# DEVIATION REQUEST AND DECISION FORM

Project Name : Judge Orr Eastonville Commercial Center  
Schedule No.(s) : 4232302003  
Legal Description : LOT 1177 WOODMEN HILLS FIL NO 10

# Deviation 2\_v1\_redlines.pdf Markup Summary

Deviation Exhibit 1

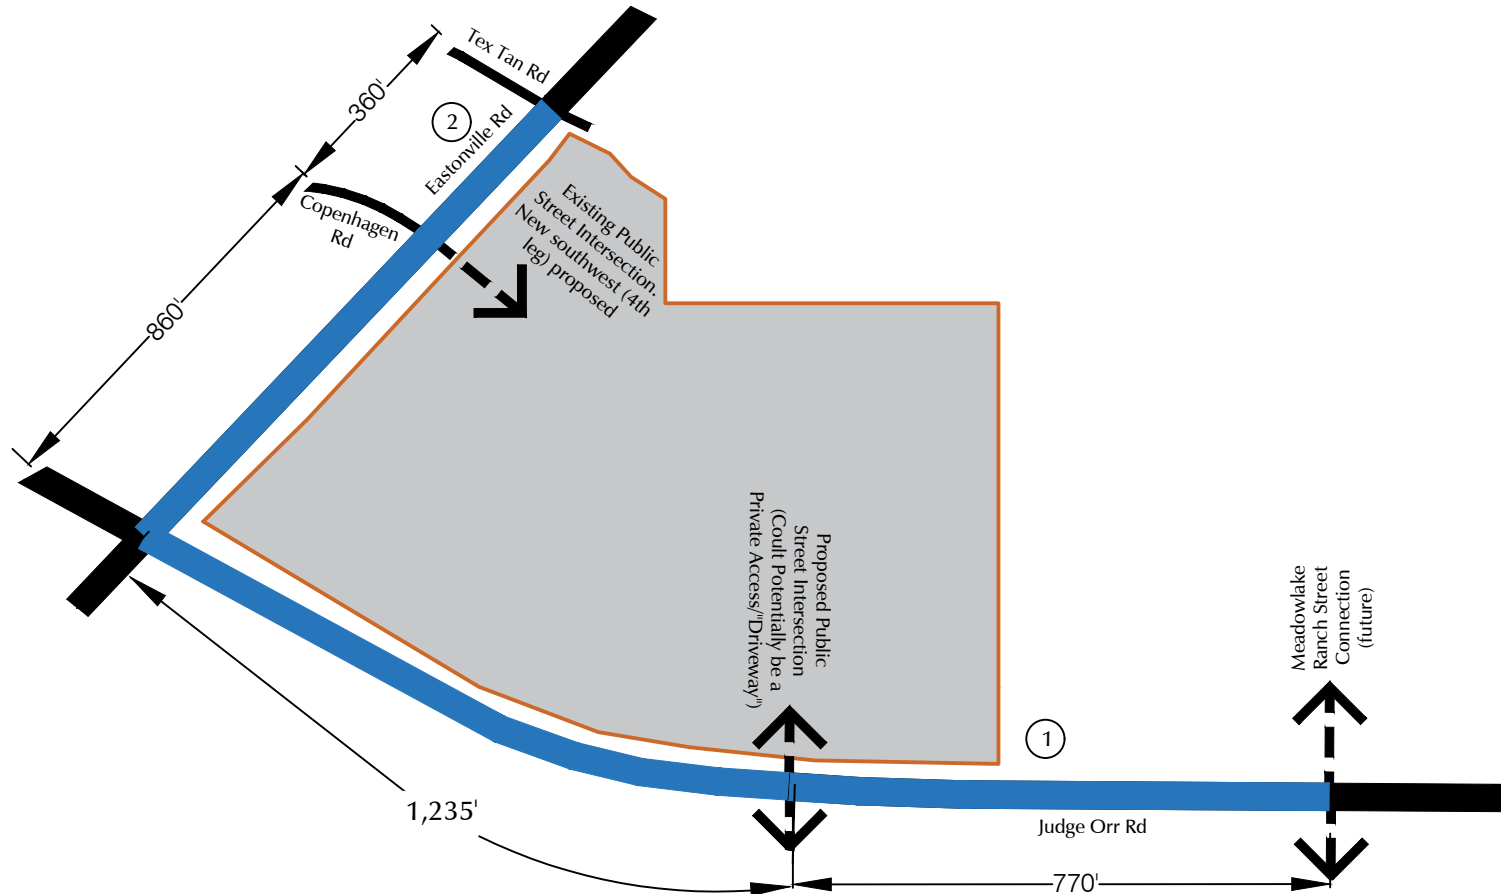
Suggest indicating that the proposed roadway would align with the existing Copenhagen Road.

Please discuss the intersection sight distance at this intersection
